Appeal Decision

Appeal Ref: APP/R5510/D/20/3250793 27 Eastbury Road, Northwood HA6 3AJ

- The appeal is made under section 78 of the Town and Country Planning Act 1990 against a refusal to grant planning permission.
 - The appeal is made by Mr T Shah against the decision of London Borough of Hillingdon.
 - The application Ref 75352/APP/2020/183, dated 15 January 2020, was refused by notice dated 23 March 2020.
 - The development proposed is described as 'a two storey front extension, part two storey part single storey rear extension, conversion of roof space to habitable use to include 3 x side dormers and 3 x roof lights and conversion of garage to habitable use.'
-

PROPOSED SIDE ELEVATION
Scale 1:100

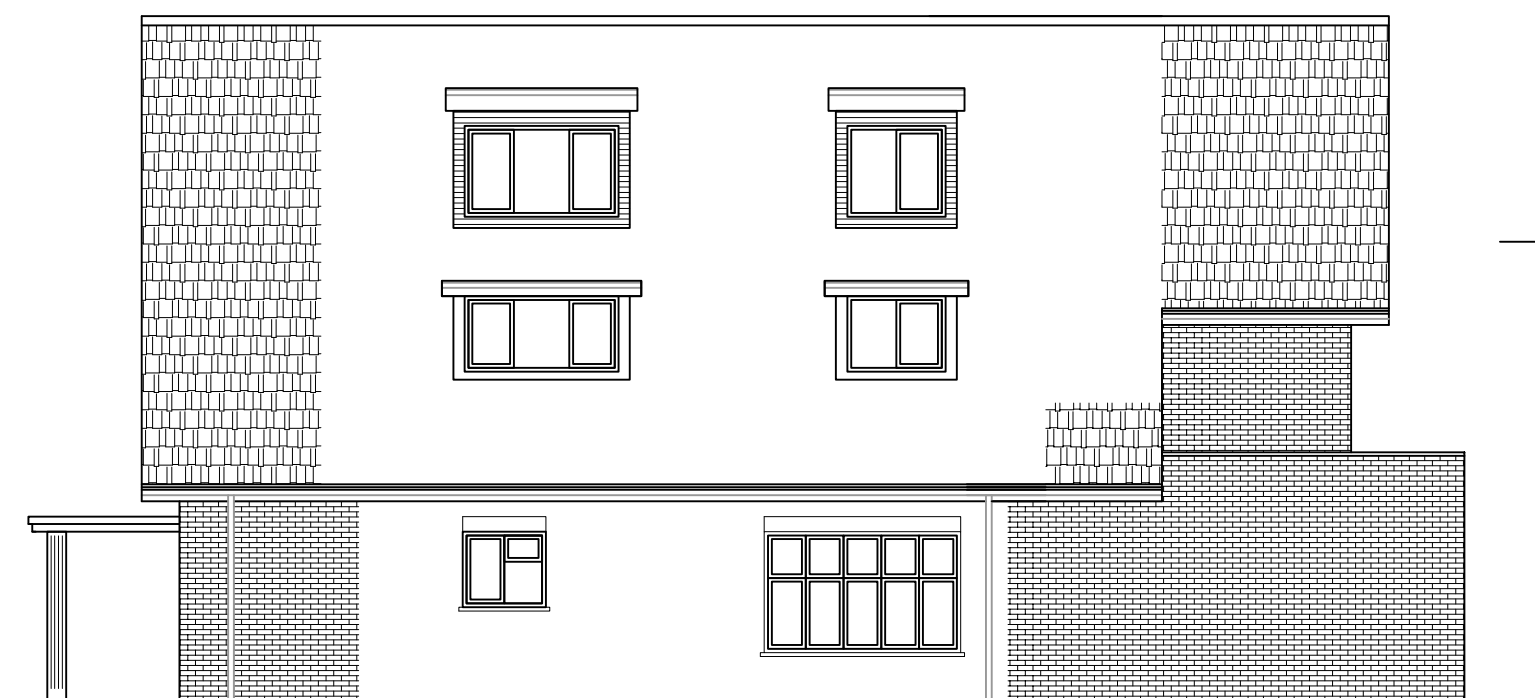
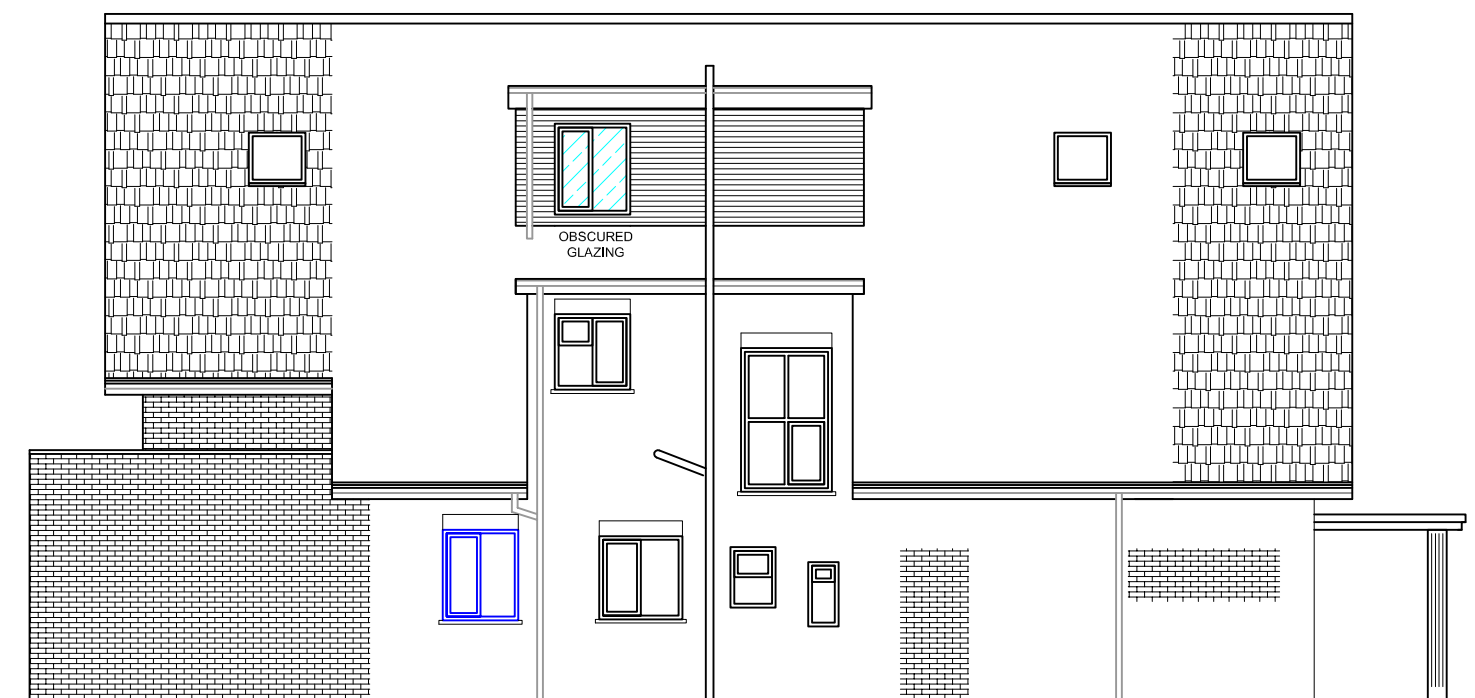
7. The appeal house has a distinct triangular roof form with existing side dormer windows set low on the roof slope and back from the front elevation. The location of the proposed dormers directly above those existing would result in an awkward roof composition with a two-tiered appearance. Although set back from the front elevation, they would be high on the roof and clearly visible from Eastbury Road even above the trees on the boundary. As a result, I find the proposed dormers would dominate the simple triangular roof appearance therein causing harm to the character and appearance of the street scene and CA.

10. In conclusion, I find the 3 x side dormers would cause harm to the appearance of the street scene and fail to preserve or enhance the character and appearance of the Northwood Frithwood Conservation Area. This conflicts with Policies BE1 and HE1 of the Hillingdon Local Plan: Part One – Strategic Policies (2012), and Policies DMHB4 of the Local Plan: Part 2 – Development Management Policies (2020) (DMP). Amongst other things, these policies seek to ensure development does not result in harm to heritage assets and maintains the quality of an area.
11. I am satisfied that the other extensions serve to preserve the character and appearance of the CA and do not conflict with any of the policies listed above. There is also no conflict with DMP Policy DMHD1 because the front extension would not alter the overall appearance of the house or dominate the character of the street.

1. The appeal is dismissed insofar as it relates to 3 x side dormers. The appeal is allowed insofar as it relates to a two storey front extension, part two storey part single storey rear extension, conversion of roof space to habitable use to include 3 x roof lights and conversion of garage to habitable use and planning permission is granted for a two storey front extension, part two storey part single storey rear extension, conversion of roof space to habitable use to include 3 x roof lights and conversion of garage to habitable use at 27 Eastbury Road, Northwood HA6 3AJ in accordance with the terms of application, Ref 75352/APP/2020/183, dated 15 January 2020, and the plans submitted with it, so far as relevant to that part of the development hereby permitted and subject to the following conditions:

8. The appeal house is currently 2-storey with its gable fronting Eastbury Road. The proposed front extension would align with the existing projecting garage bringing the building broadly in line with its neighbour at No.25 Eastbury Road. Although closer to the road, it would remain set well back and the original form and overall appearance would be retained. Importantly, the triangular roof of the original house, which the Council consider distinctive and adds interest to the street scene and CA, would not be lost.

9. The white banding over the converted garage replicates the existing and provides relief and interest to an otherwise brick elevation. Whilst the proposed ground floor windows on the front elevation would not match, they would be of a similar design and proportions and I find these appropriate to the simple architecture of the house. The proposed double front door with open porch would be more prominent than the recessed single front door of the original house. It would, however, be in proportion to the scale of the front elevation and would not overly dominate it. Overall, I find the architectural detailing to the front elevation to be sympathetic to the composition of the house and would not harm its appearance.
